Recommendation Report for Planning Permission for Works or Extension to a Dwelling

REF NO: BN/4/21/HH

LOCATION: Magnolia Cottage
Fontwell Avenue
Eastergate
PO20 3RZ

PROPOSAL: Proposed two storey rear extension

Proposed North Elevation

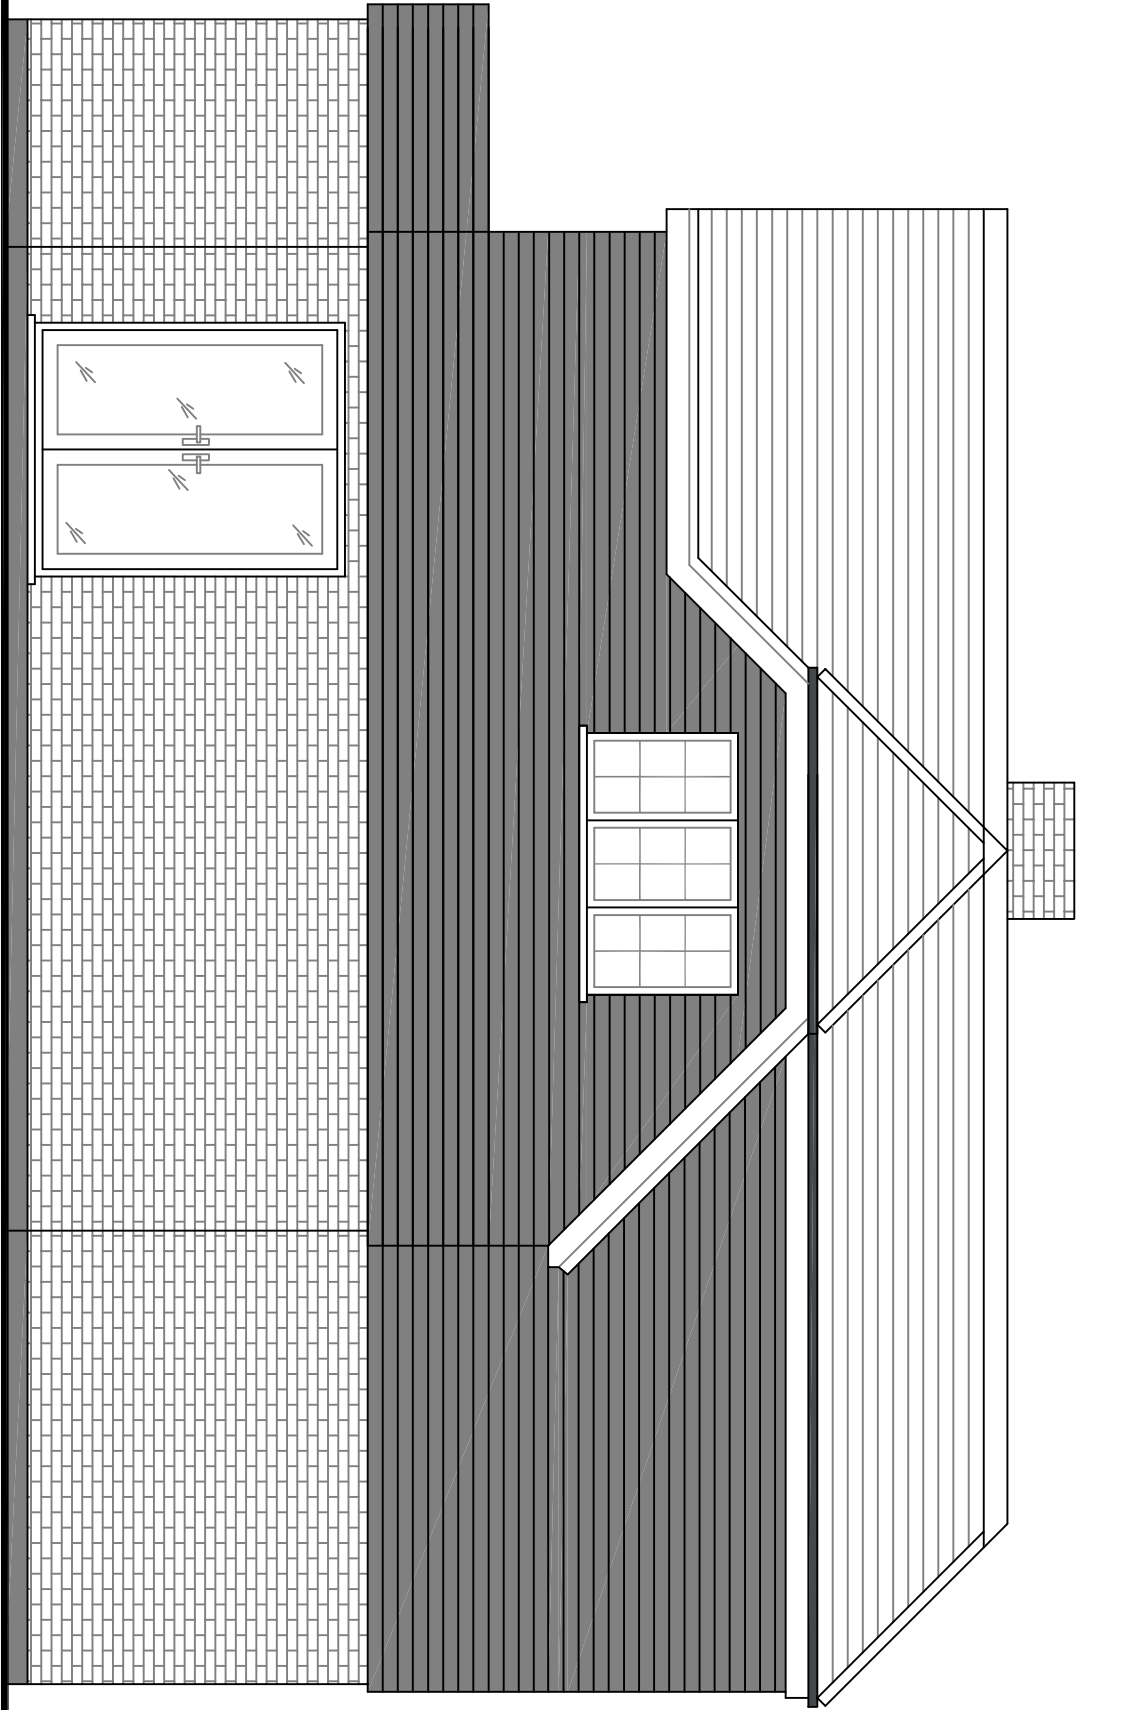
The extension is located around 0.6m from the boundary which is in relatively close proximity to the neighbouring property which features a conservatory. As such the addition may give rise to some overbearing impact. The neighbouring conservatory does however extend around 1.5m beyond that of the extension and as such it is not considered to appear unduly dominant.

The neighbouring conservatory is also located to the south and is not considered to result in adverse overshadowing as a result of two storey addition.

Proposed Ground Floor Plan

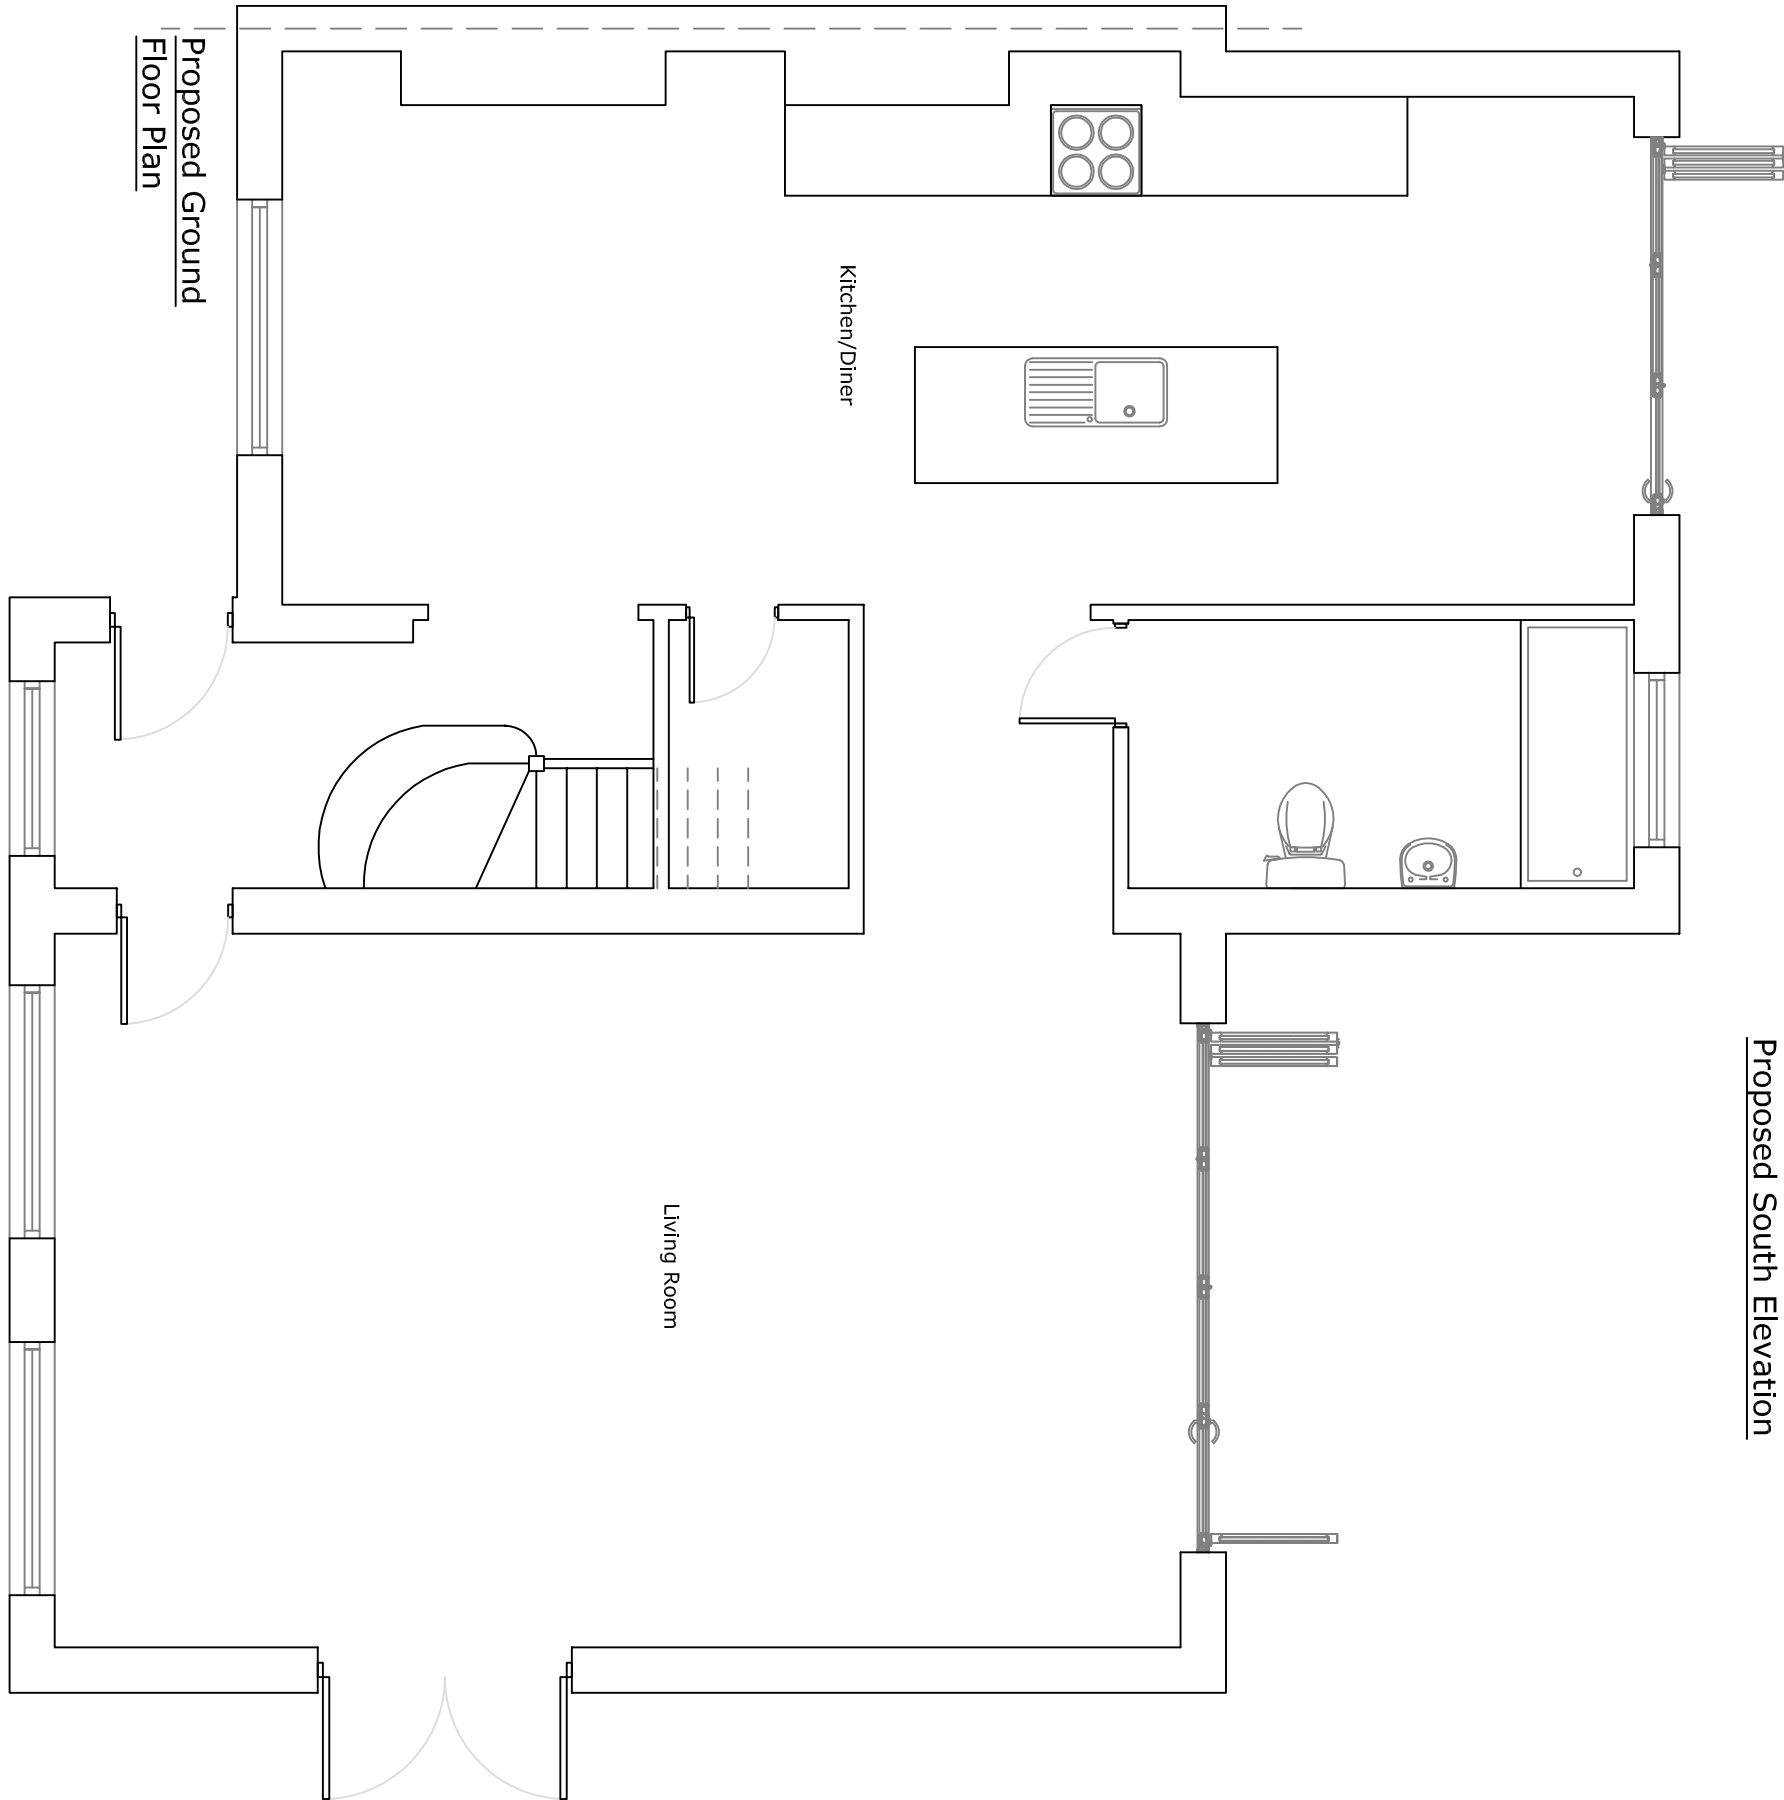
The extension will have a depth of 3m and width of around 6m. The height will match that of the host dwelling with a hipped roof.

Proposed First Floor Plan

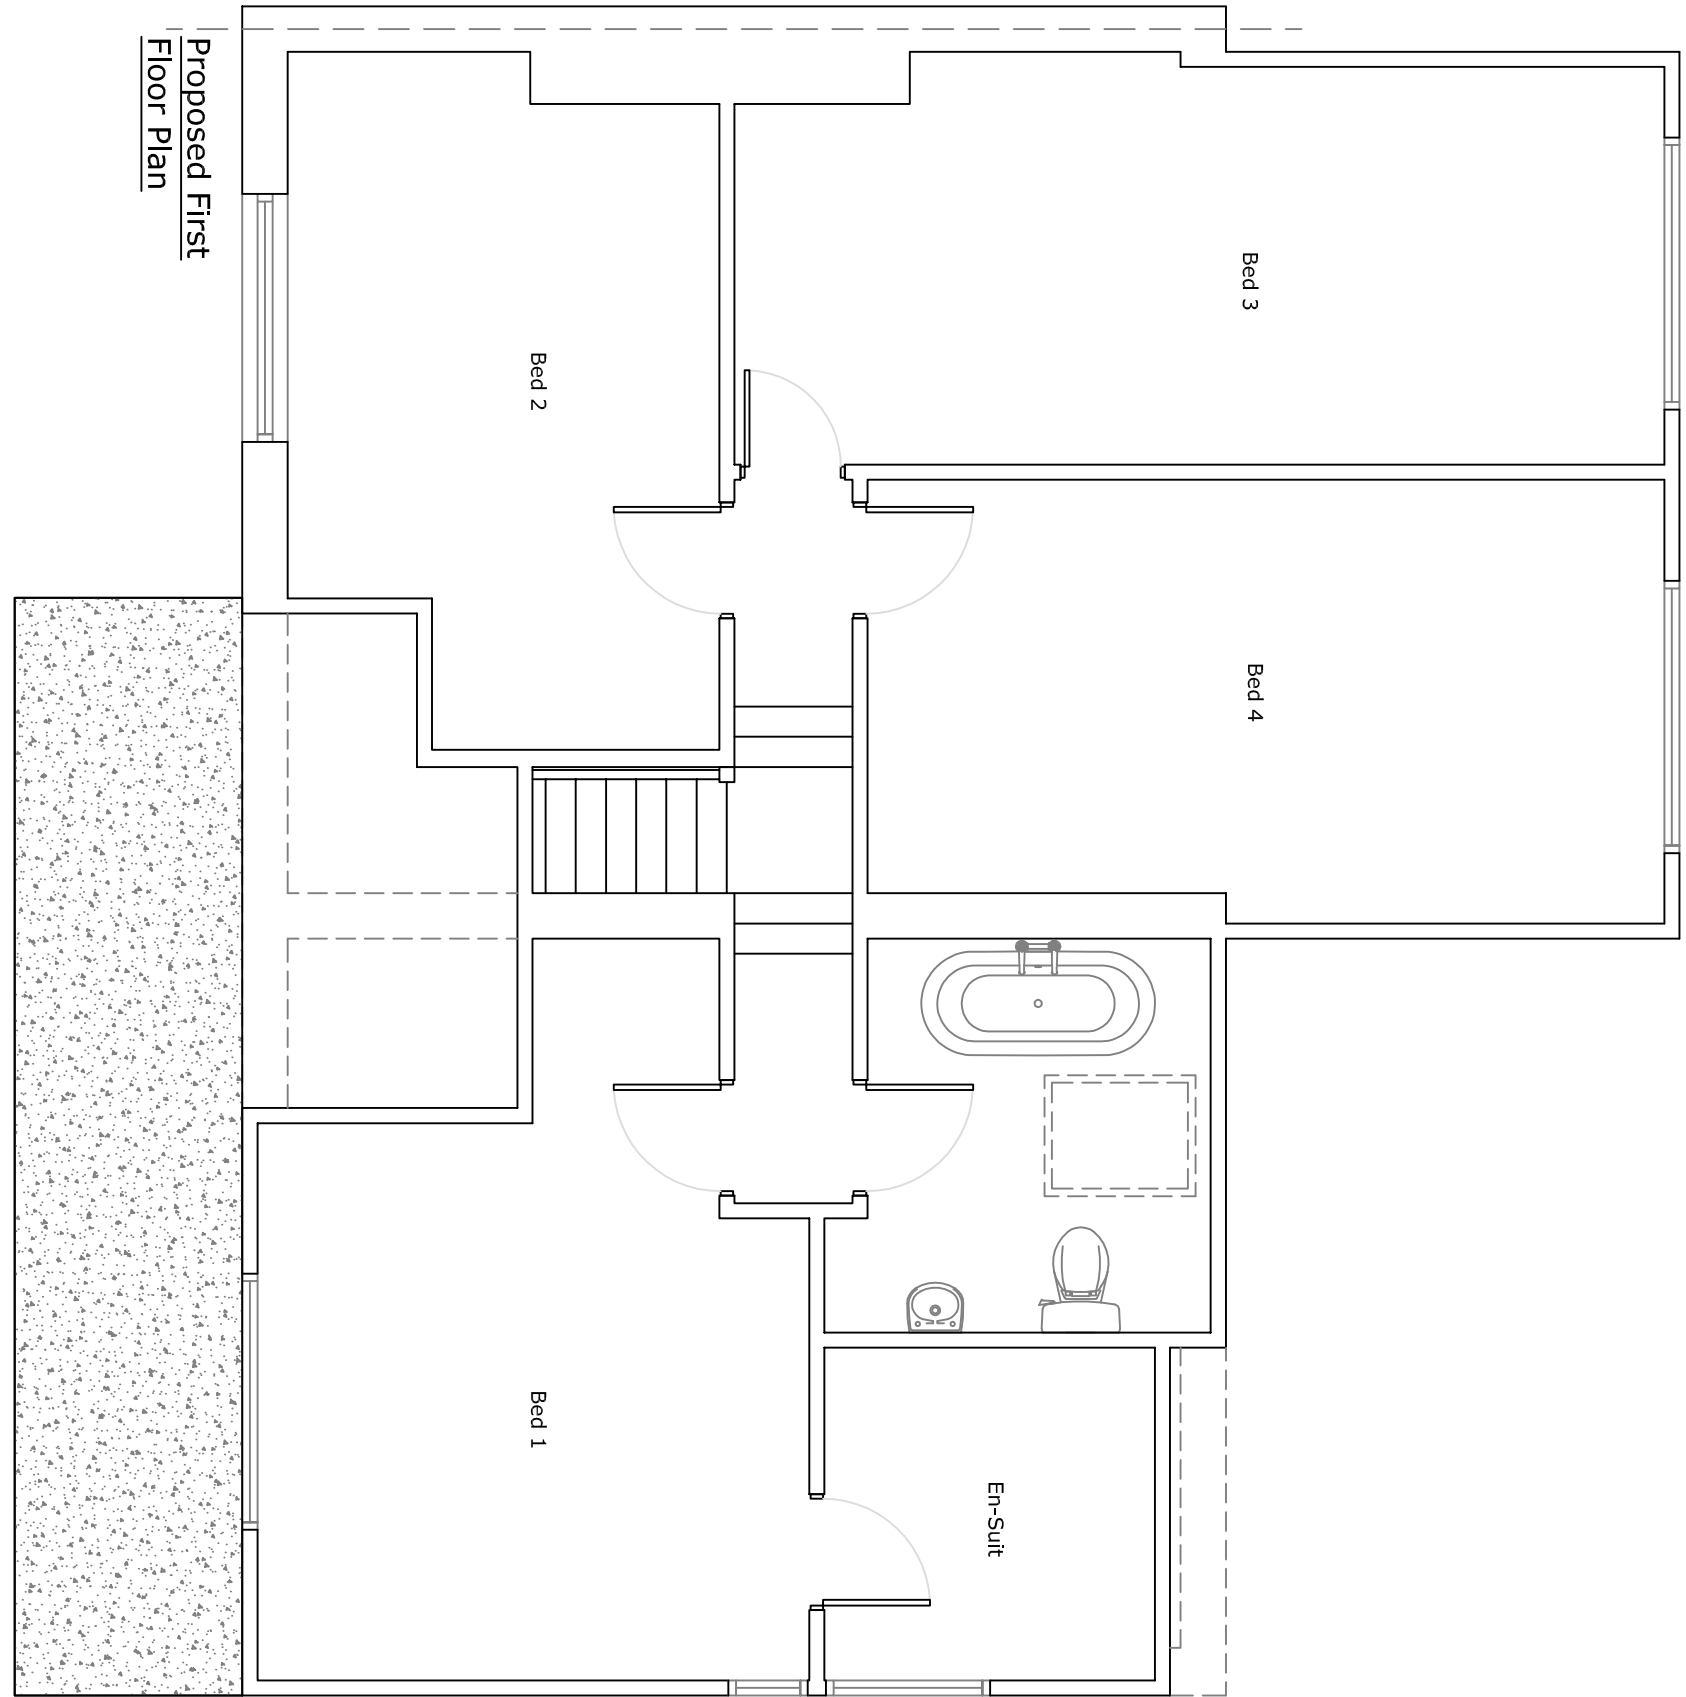
There will be 2 windows at first floor which will replace an existing dormer and rooflight. These will provide views over the garden of the host dwelling and are not considered to increase overlooking from that which is already available.
